THE ABLE MARINE ENERGY PARK DEVELOPMENT CONSENT ORDER 2012
(PINS REFERENCE NUMBER: TR030001)

COMMENTS ON THE APPLICANT'S RESPONSES TO THE EXAMINING AUTHORITY'S
FIRST SET OF WRITTEN QUESTIONS (QUESTIONS 35 AND 36)

E.ON UK PLC

July 2012

Figure 29 Longer term potential morphological response along intake-outfall line (E.ON)

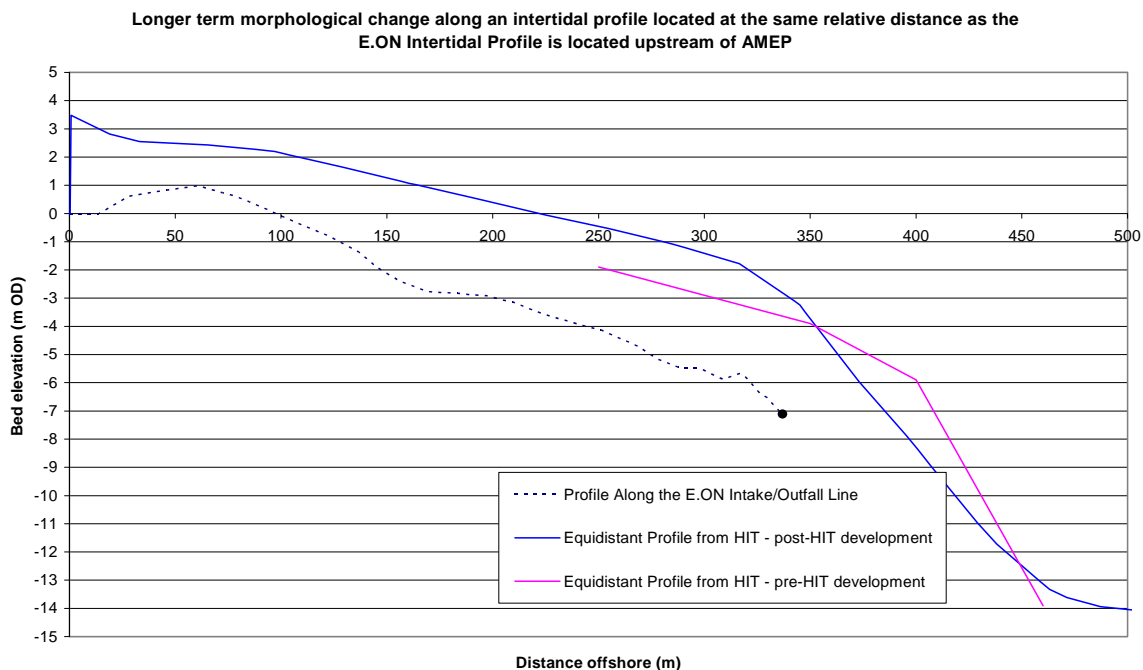
- 3.9 E.ON therefore remains concerned about the likelihood of sediment build up and the likely need for maintenance dredging in relation to the current locations of intake and

outfall and E.ON remains concerned regarding proposals for the relocation of its outfall.

Figure 2.1 Site layouts; existing and revised developed case

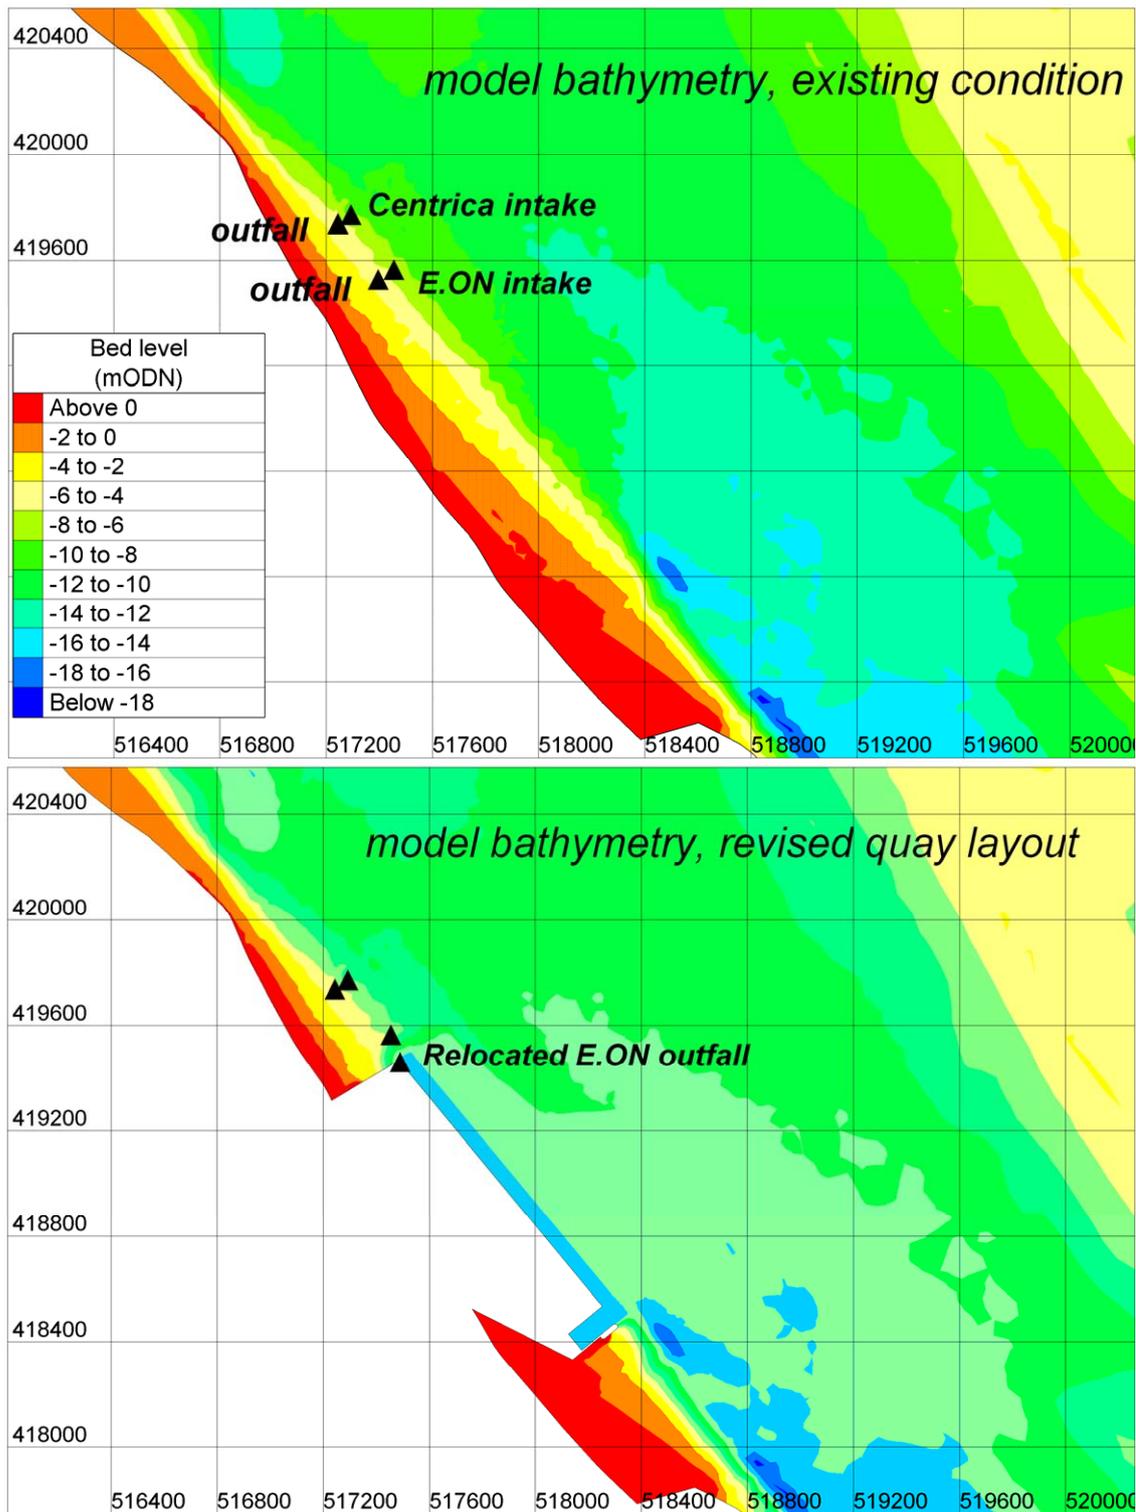
- 3.4 One possible position for the relocated E.ON outfall has been considered in the applicant's Supplementary Report Ex 9.7 (Assessment of the Effects of Relocation of the E.ON and Centrica Outfalls on Thermal Recirculation). The relocated position in EX 9.7 would also need to be considered in the context of ships potentially berthing close to the outfall and affecting dispersion conditions. The importance of the Cooling Water system to the operation of Killingholme Power Station has already been highlighted earlier in these submissions at paragraph 1.3. Accordingly, any movement of E.ON's intake or outfall pipe must be subject to the agreement of E.ON.

- 3.5 If the E.ON outfall were to be moved, a range of possible new locations would need to be assessed, including outfall locations further offshore. Additionally, a variation to the E.ON Killingholme Environmental Permit would be required to move the outfall location. This would have to be negotiated with the Environment Agency, which may take some time. Modelling would have to be presented to the Environment Agency and a Habitats Assessment would probably be required. Effectively it would be the Environment Agency that confirms whether or not a new outfall location would be acceptable as it would be the Environment Agency granting the Environmental Permit. E.ON wishes to note that the applicant has the responsibility for carrying out any additional modelling work required as part of any proposals to move the intake or outfall locations.
